CITY OF ALBUQUERQUE

July 21, 2017

**Re: Winrock Town Center – Phase B
2100 Louisiana NE
Request for Certificate of Occupancy- Hydrology
90-Day Conditional Shell Completion Approval
Engineer's Stamp dated: 3/11/16 (J19D058E)
Certification dated: 6/21/17**

A2 PARTIAL SITE PLAN
SCALE: 1/8" = 1'-0"

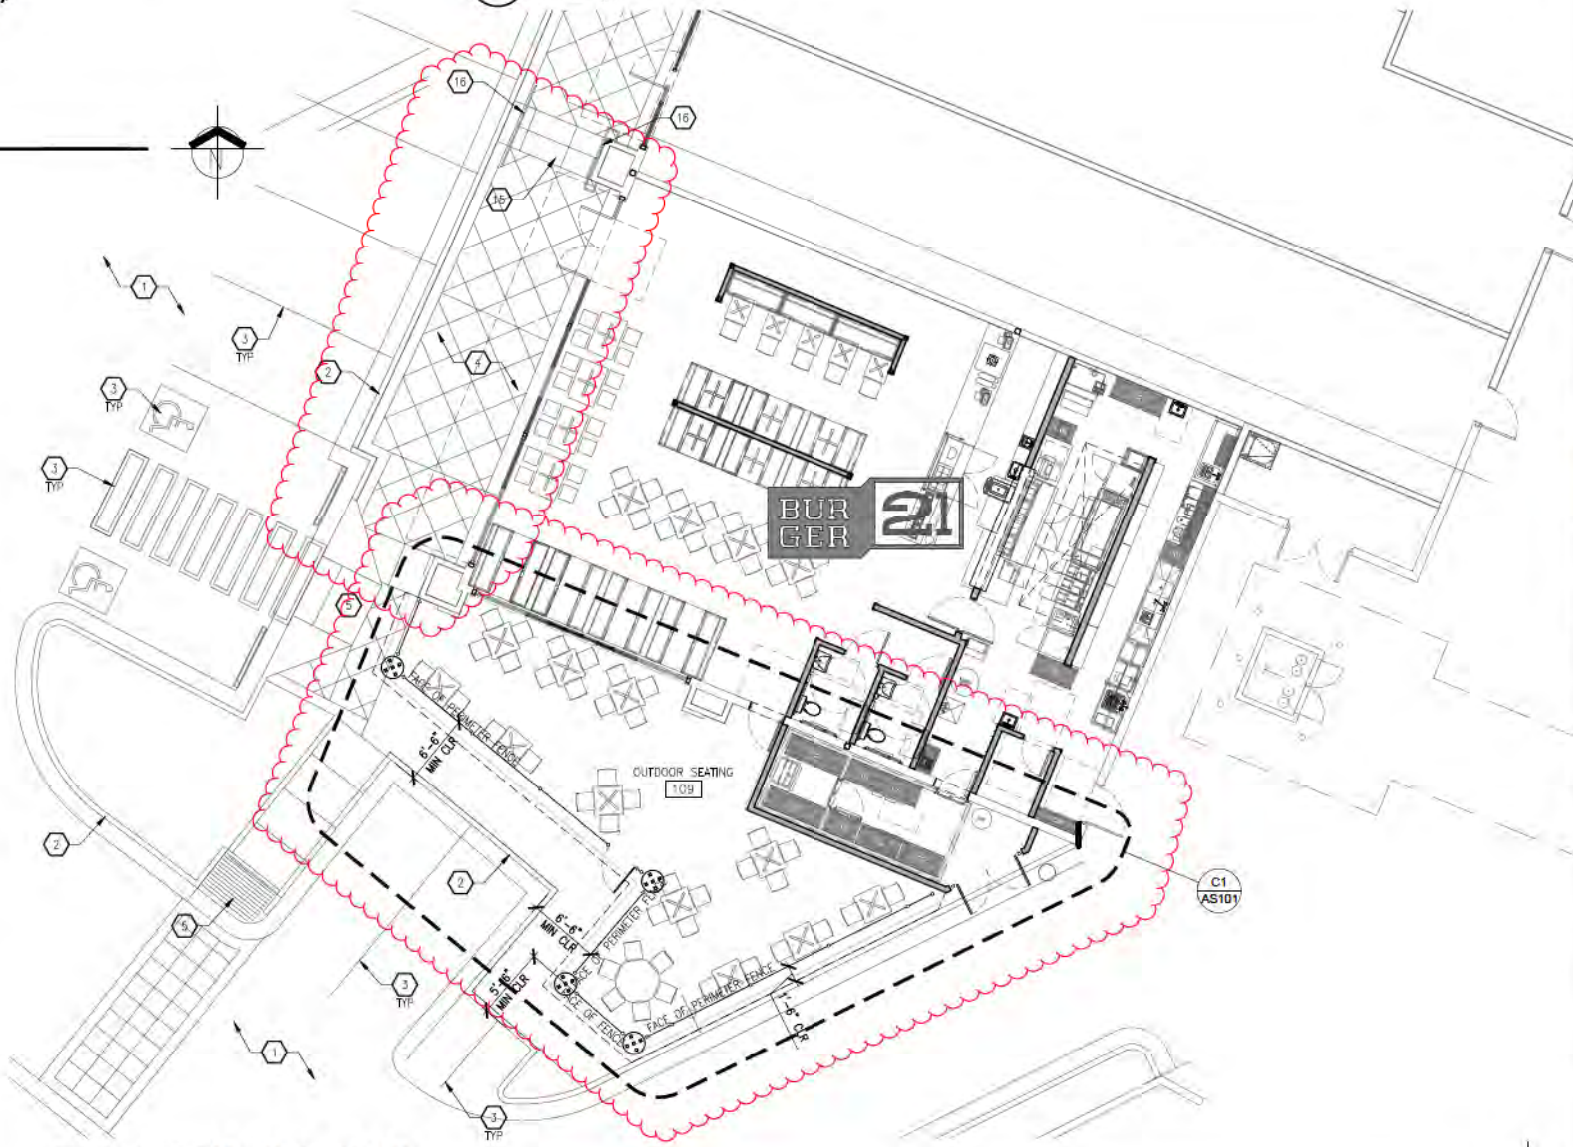
4. The new patio on the east side of the building must be completed, reflected on the drainage certification, and accompanied by an approved administrative amendment. The drainage certification needs to address how this area will drain.

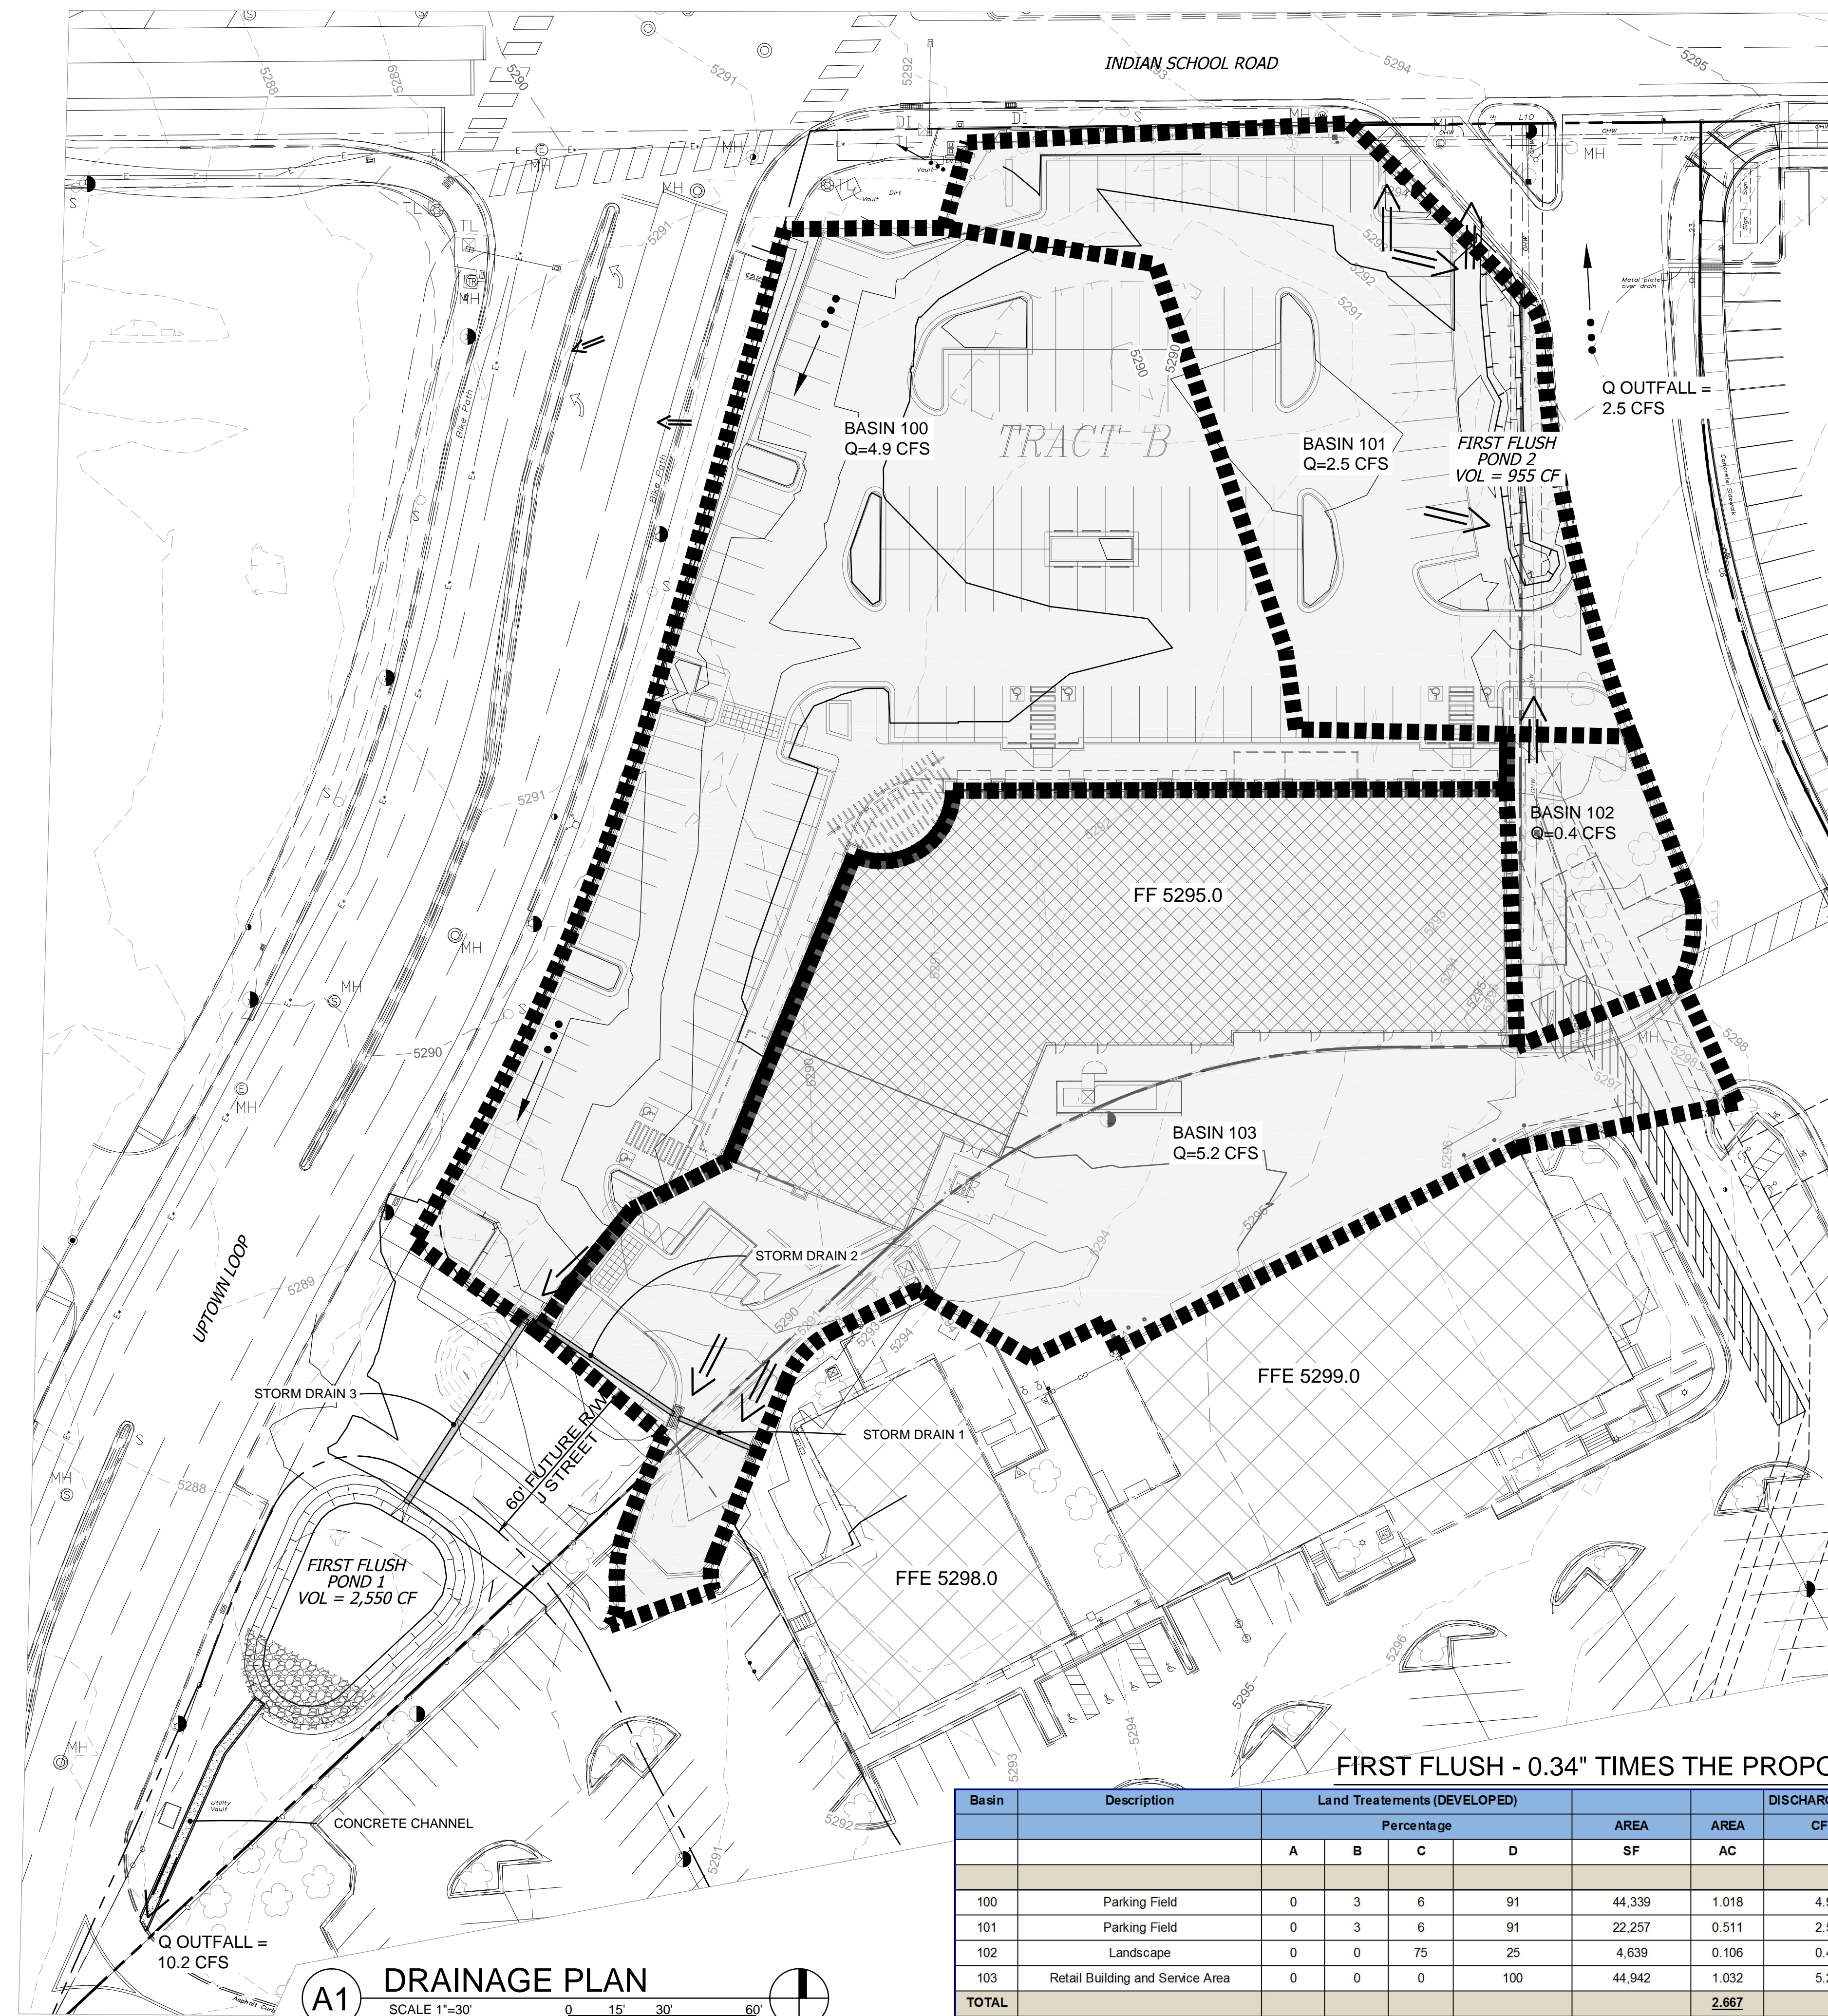
1. The conditions of Building Permit must be addressed. See Building Permit letter dated 4/29/16 from Rita Harmon.
2. The sidewalk culvert into pond 2 (east side of the site) needs to be bolted down and tack-welded.

3. The taped-over PVC pipe penetration into the south end of pond 2 that is not shown on plans. Its function and hydraulic characteristics (size, slope, alignment, capacity) need to be reflected on the drainage certification.

5. On the east side of the building, south of the patio, there is a low spot that looks like it will pond water against the building wall at or above the finished floor elevation. Additional survey is needed here to confirm drainage and mitigation action is likely needed to drain water away from the building.

6. The new patio on the southwest side of the must be completed, reflected on the drainage certification, and accompanied by an approved administrative amendment. The drainage certification needs to address how this area will drain.
7. The rock lined channel needs to be upsized and re-surveyed to account for freeboard (see DPM Ch22.3.C.4), increased friction losses, and the new geometry. The hydraulic capacity calculations need to reflect the surveyed conditions including running slope, side slopes, top, and bottom width.
